**Application by East Anglia ONE North Limited for an Order Granting Development Consent for the East Anglia ONE North (EA1N) Offshore Windfarm project; and
Application by East Anglia TWO Limited for an Order Granting Development Consent for the East Anglia TWO (EA2) Offshore Windfarm project**

Outline Operational Drainage Management Plan

We have reviewed the Outline Operational Drainage Management Plans (OODMP) submitted at Deadline 8, for both EA1N and EA2 (both Doc. Ref. ExA.AS-3.D8.V4, both dated 25 March 2021).

Appendix 2: ~~Infiltration-SuDS~~ Outfall Concept Design ~~Model Outputs~~ to the Friston Watercourse

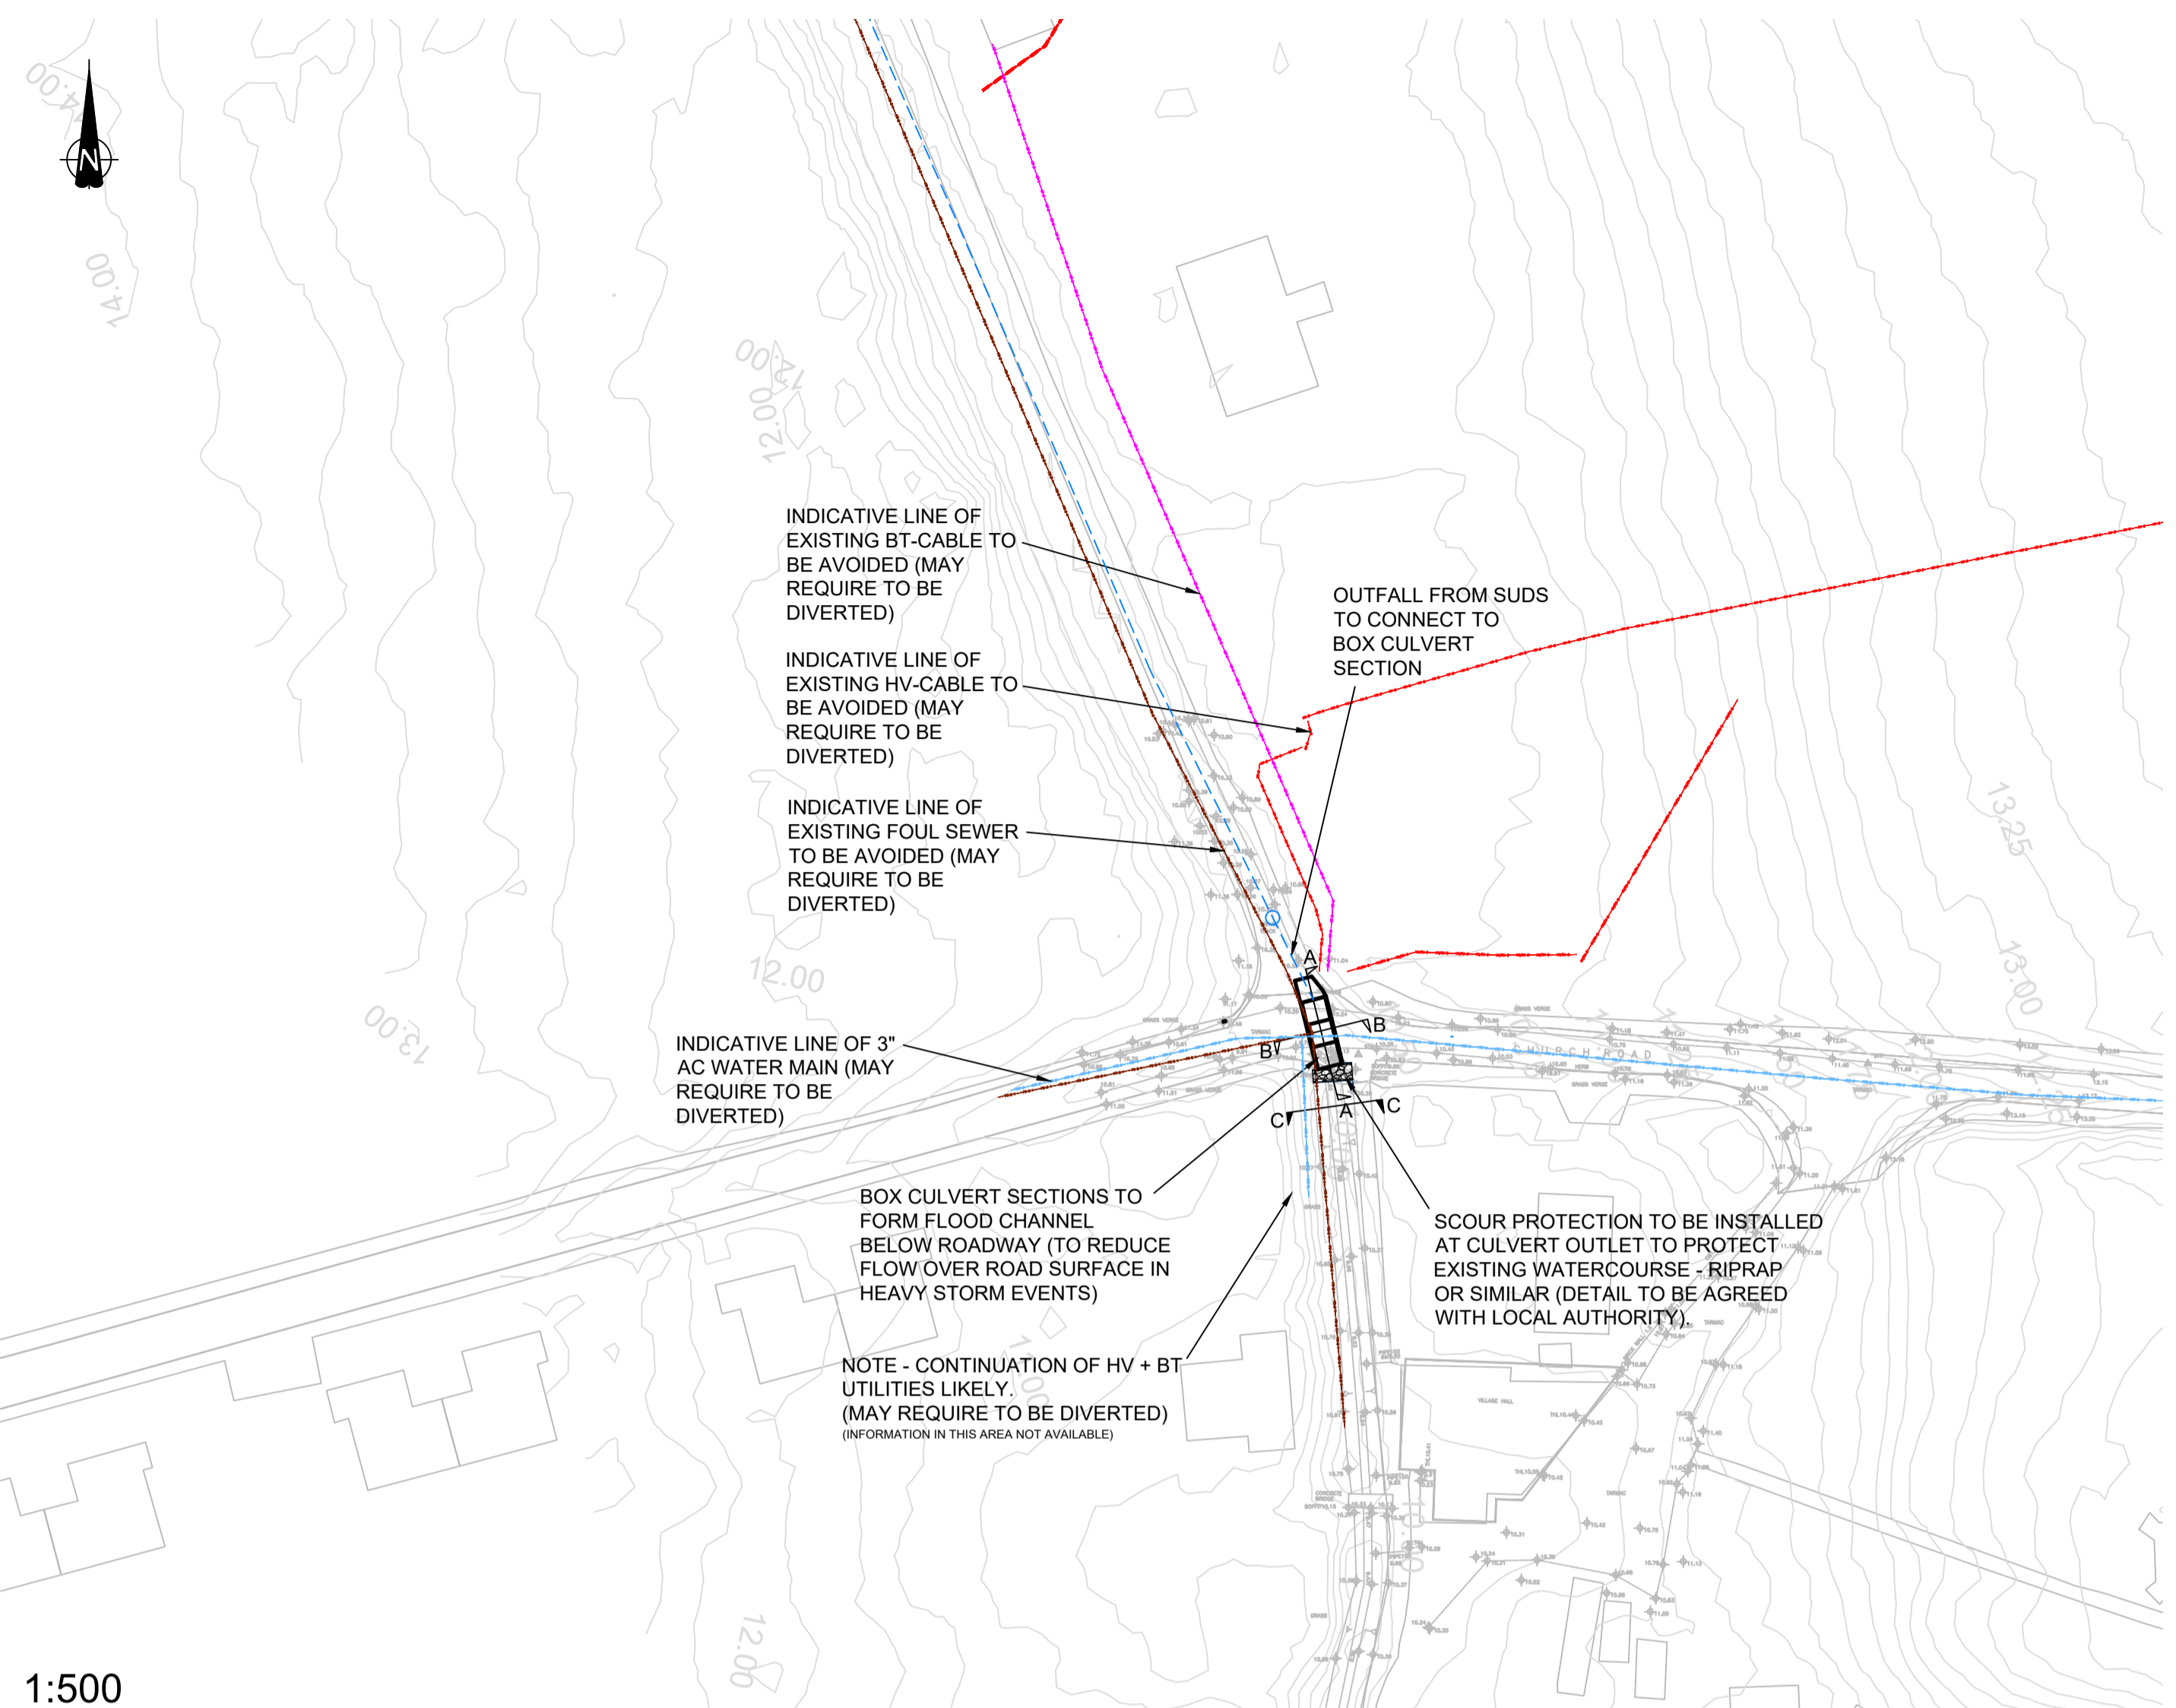
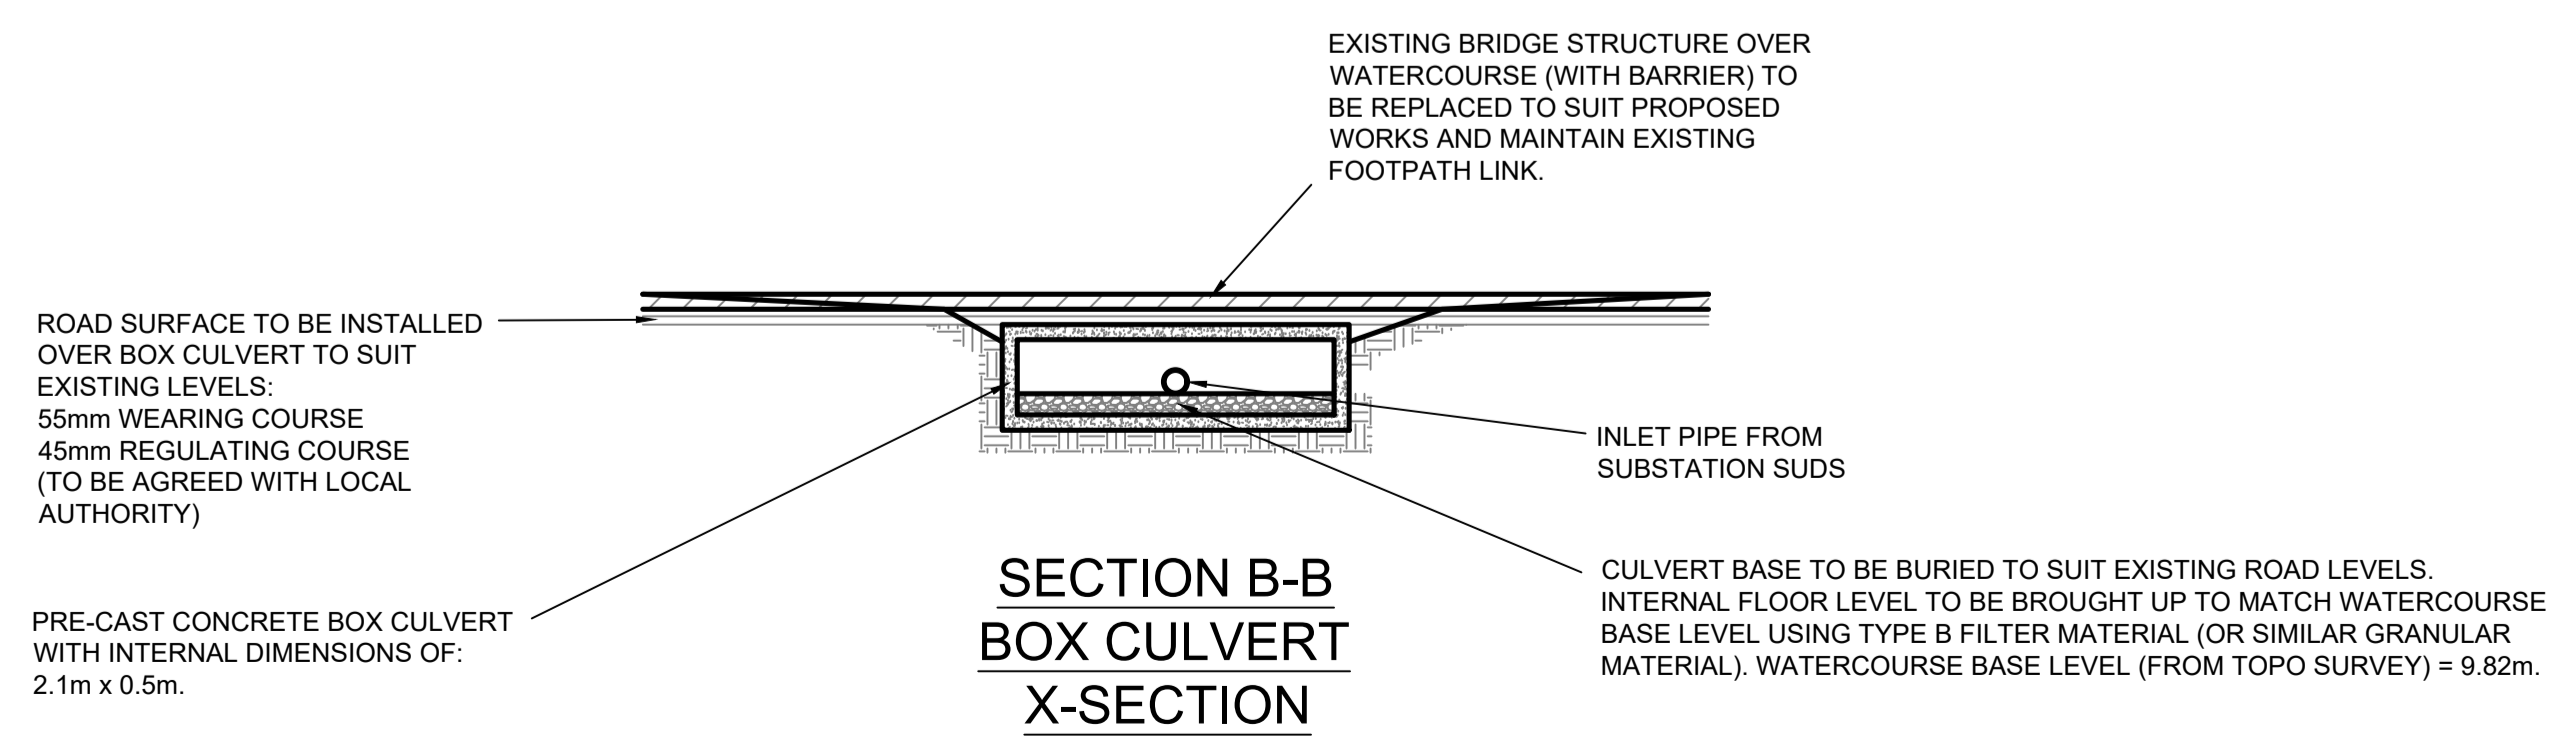
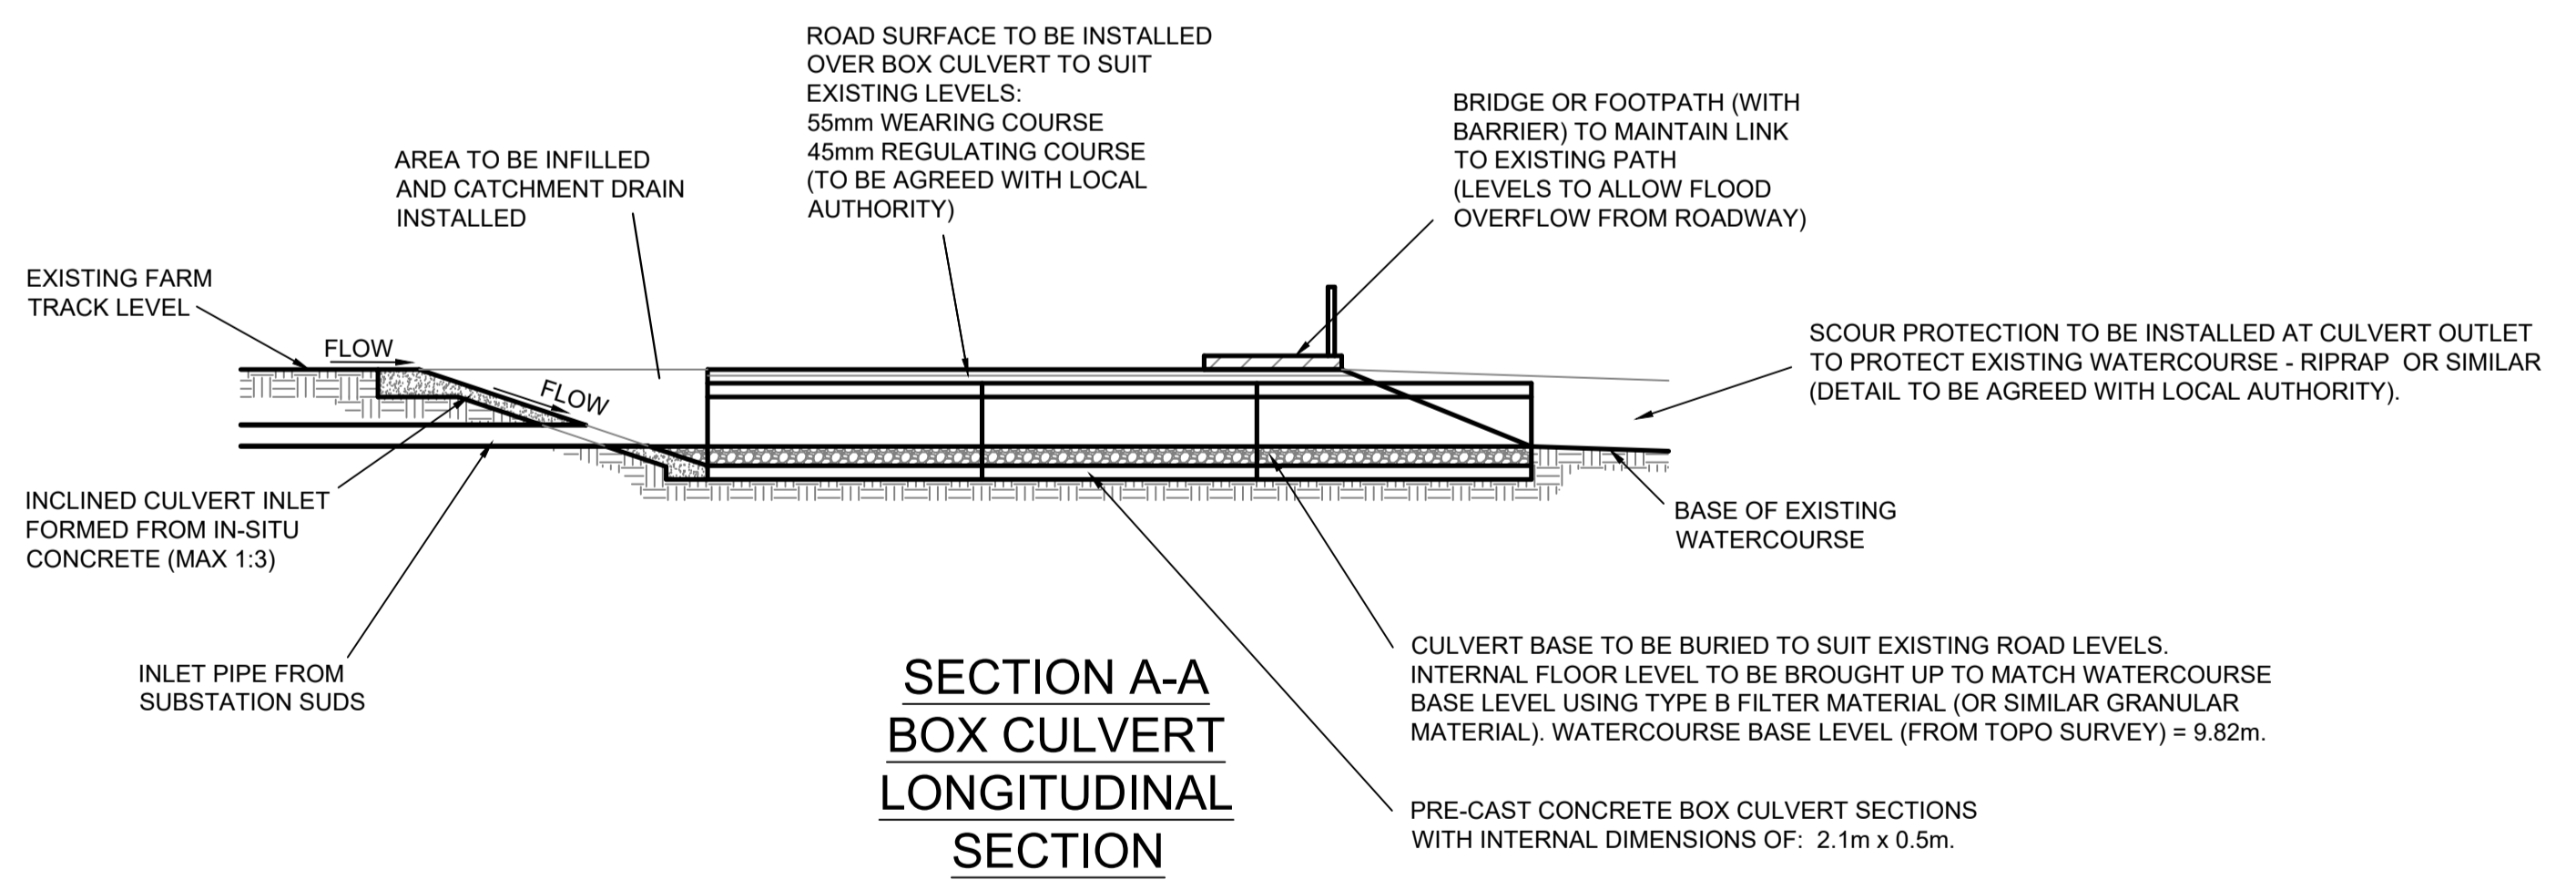
We note the addition of Plate 3 and Appendix 2 in each document, which provide some detail for a box culvert and pipe connection to Friston Watercourse, if required. We also note the inclusion of paragraph 139, which states that maintenance of the operational drainage scheme will be secured through the final Operational Drainage Management Plan.

As discussed within the OODMP documents, it will be essential to ensure that flood risk is not increased as a result of any positive discharge to Friston Watercourse. The Lead Local Flood Authority must be satisfied with the proposed rate of discharge.

Friston Watercourse currently receives a significant amount of silt, contained within the surface water run-off entering the channel from the Church Road and Grove Road areas. Therefore we would just highlight at this stage that the final SuDS scheme should be designed to ensure that the sediment load entering Friston Watercourse is not increased as a result of the proposed development, and is decreased where possible. The final design of any positive outfall should seek to

minimize the risk of blockage as a result of sediment build up in the channel. In preparing the final Operational Drainage Management Plan, the need for any on-going maintenance to ensure that the outfall remains operational and able to discharge throughout the lifetime of the development should be considered. We would need to review and approve any maintenance activities within the channel.
